# BUILDING PERMIT

Located At 251 CUMBERLAND AVE

Job ID: 2012-06-4374-ALTCOMM

has permission to Create an entrance to the basement to build a laundry room for tenant use provided that the person or persons, firm or corporation accepting this permit shall comply with all of the provisions of the Statues of Maine and of the Ordinances of the City of Portland regulating the construction, maintenance and use of the buildings and structures, and of the application on file in the department.

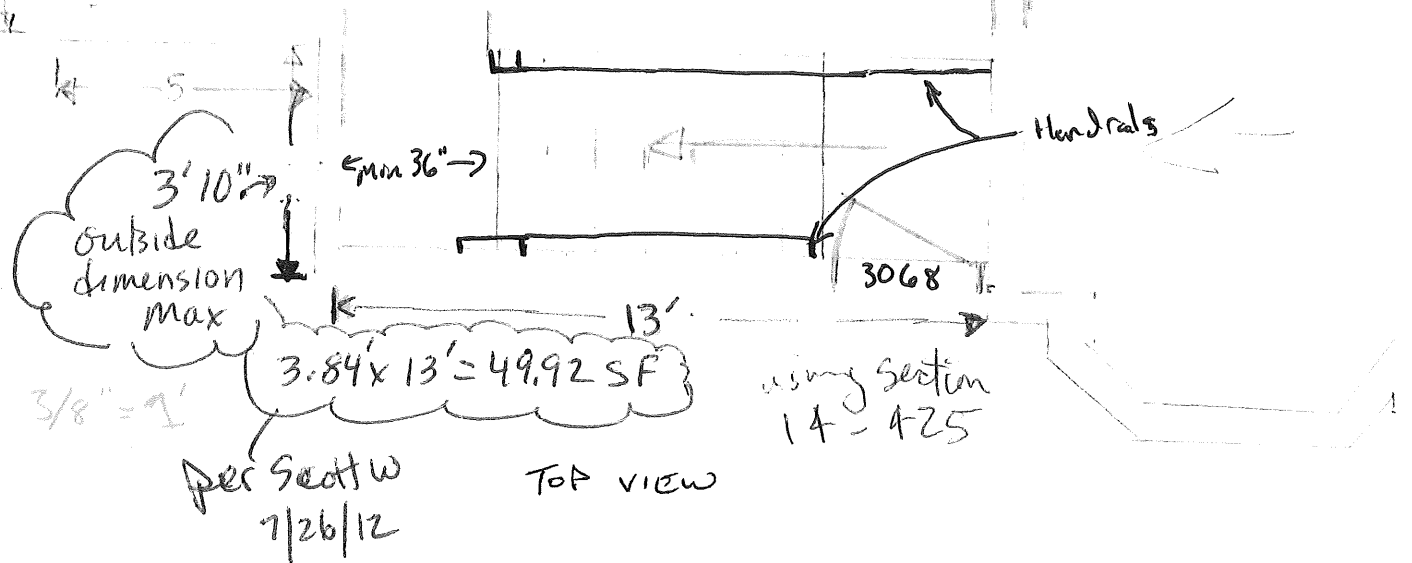
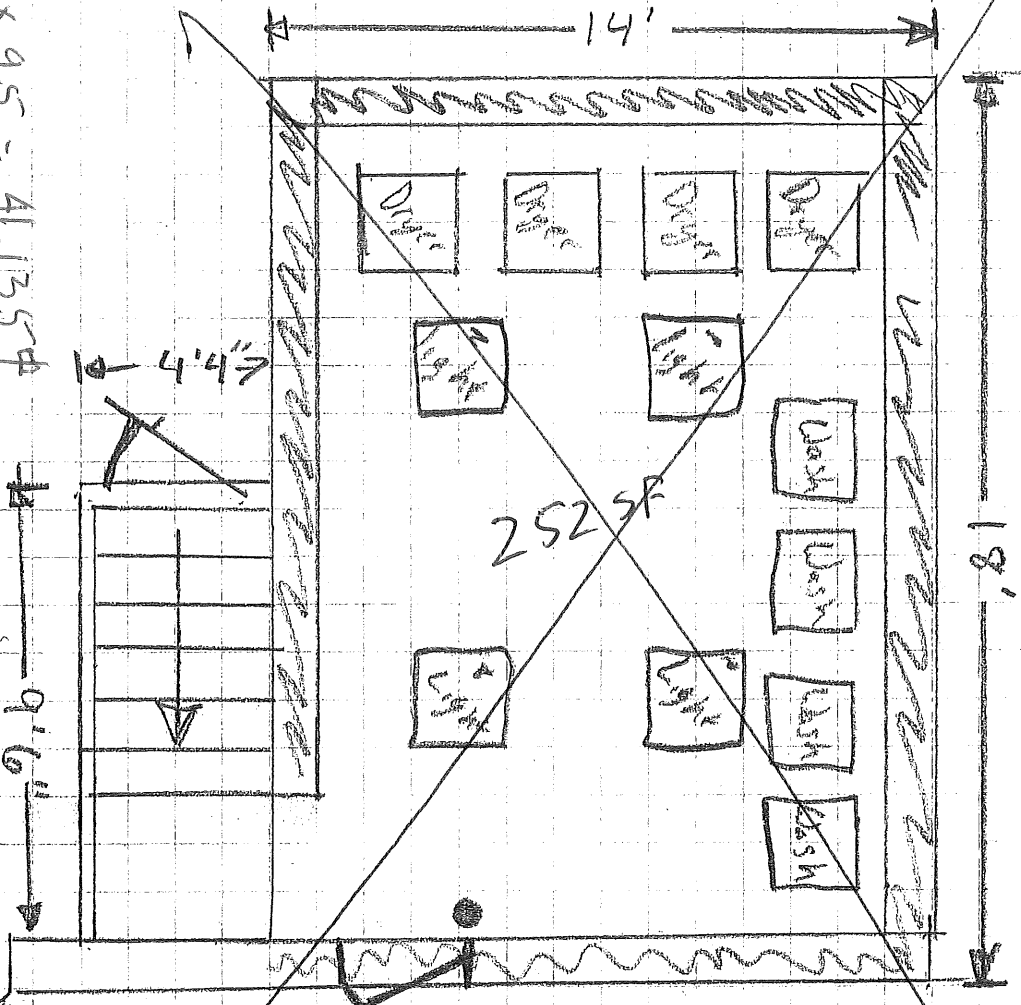
\* Nothing below 6' 9" in room.

$4.33 \times 9.5 = 41.135 \text{ ft}^2$   
using section 14.425

correct measurements  
per Susie Kendra  
Kendrick 7/13/12

ADDRESS: 251 CUMBERLAND AVENUE
PORTLAND, ME

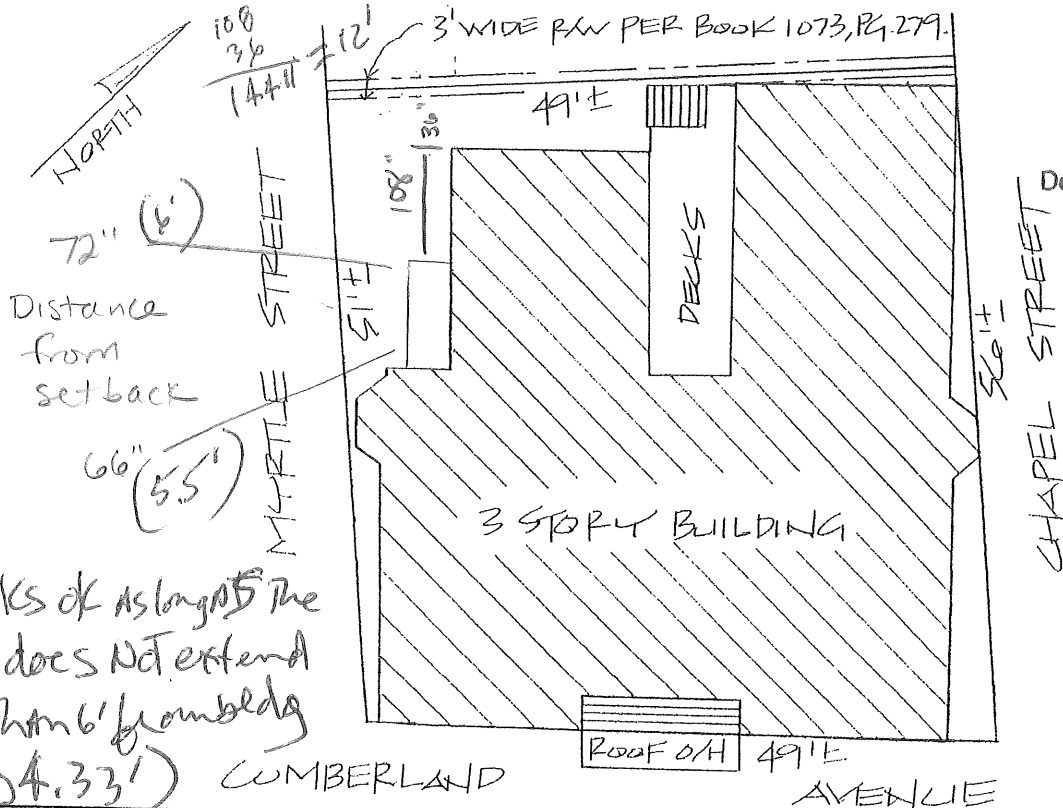
setbacks ok as long as the entry does not extend more than 6' from bldg (shown 4.33')

going on existing pavement - not increasing existing nonconforming impervious

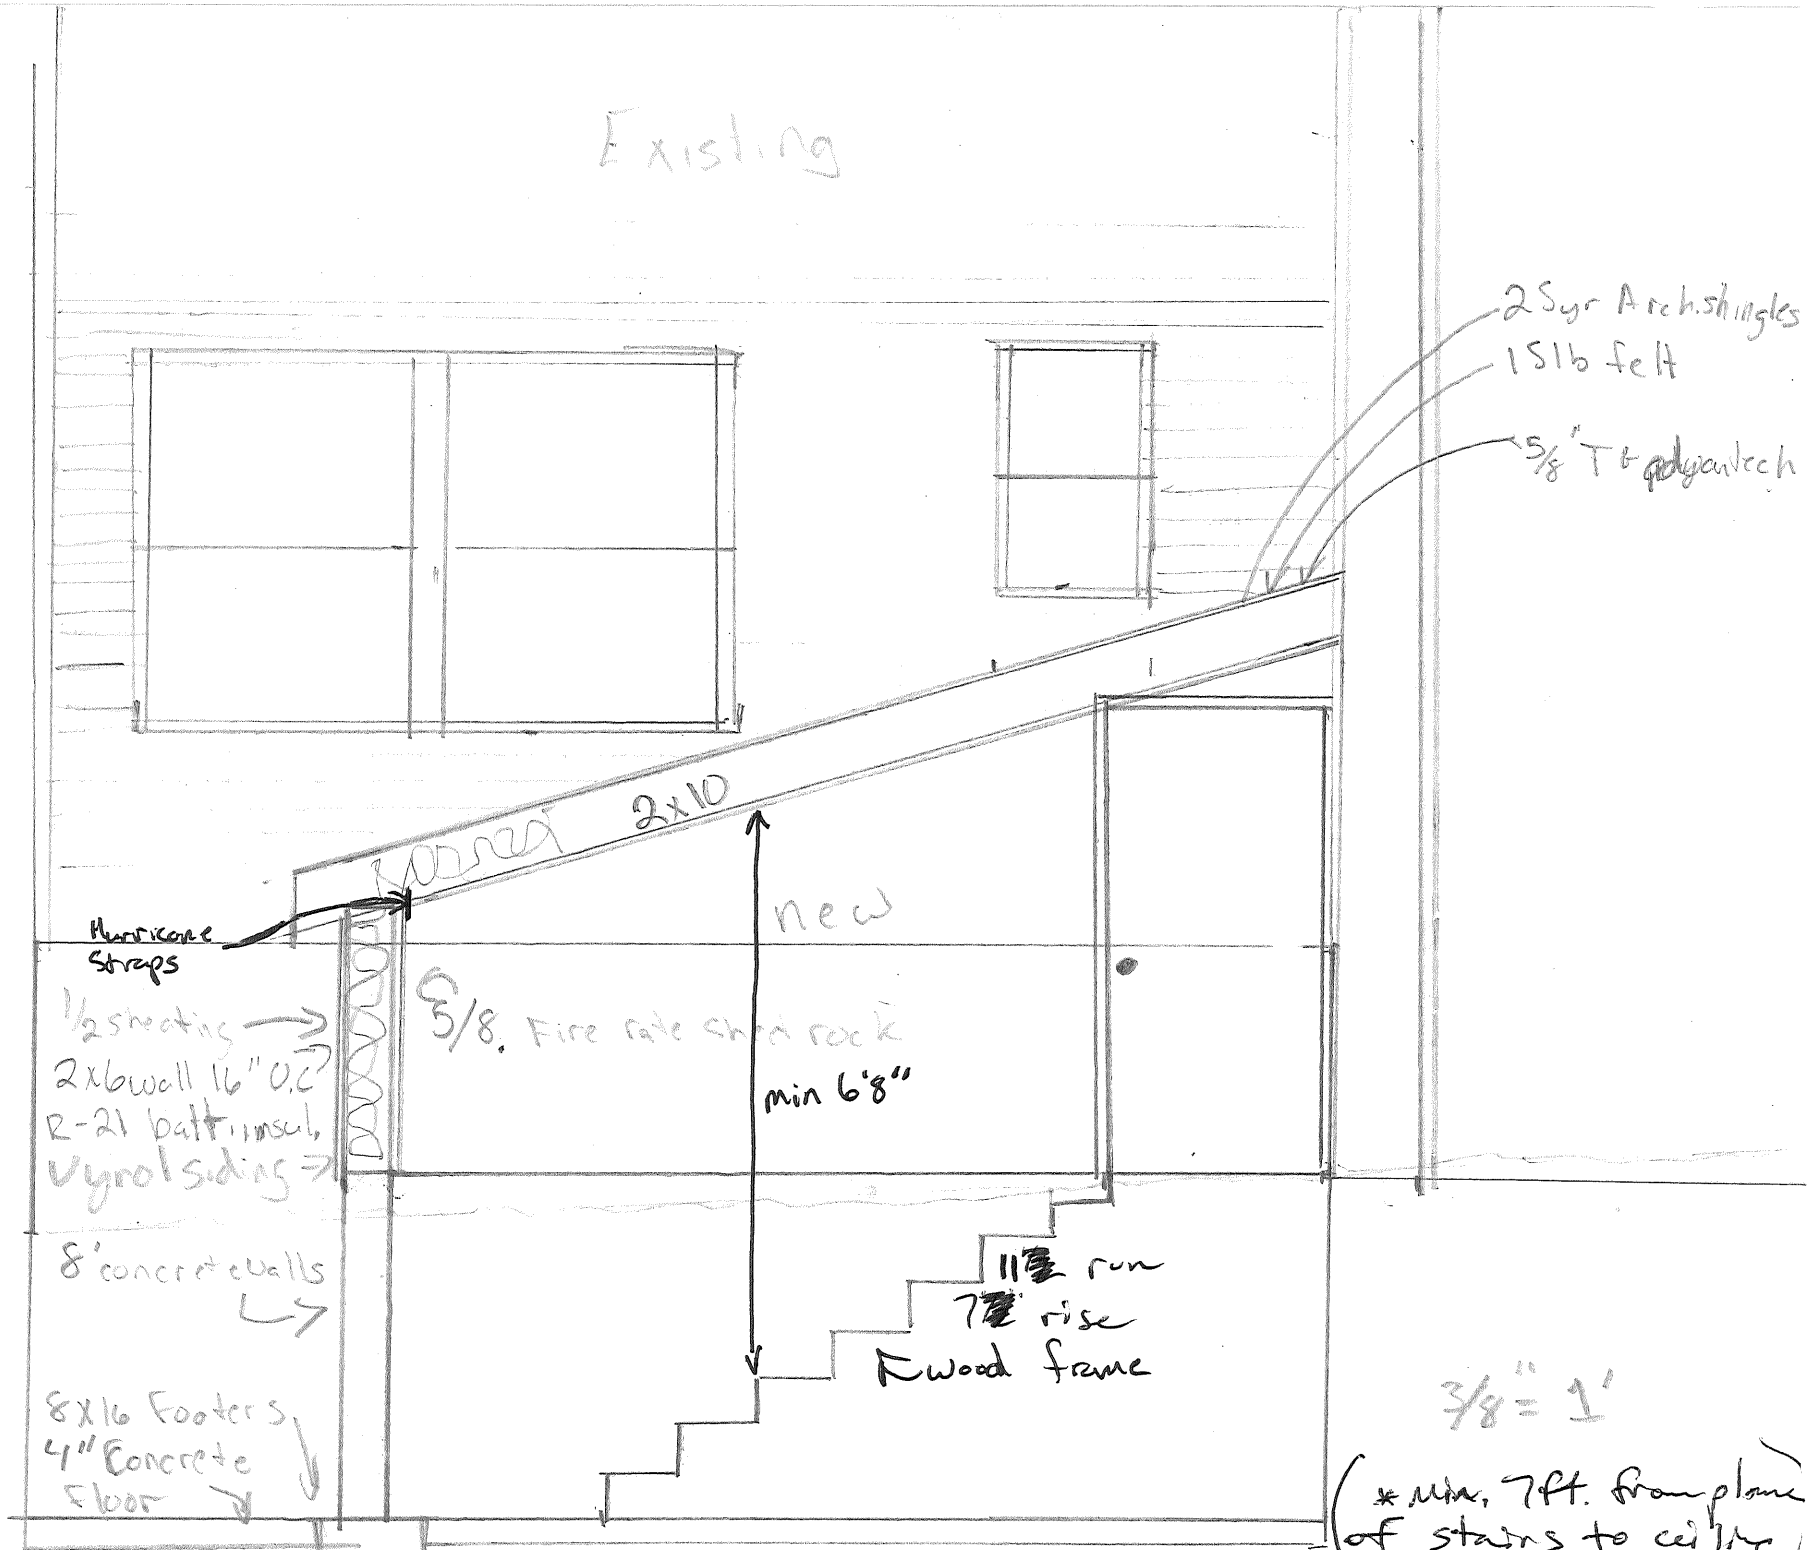
needs

5/8" Fire rate GYP rock  
min 6'8"
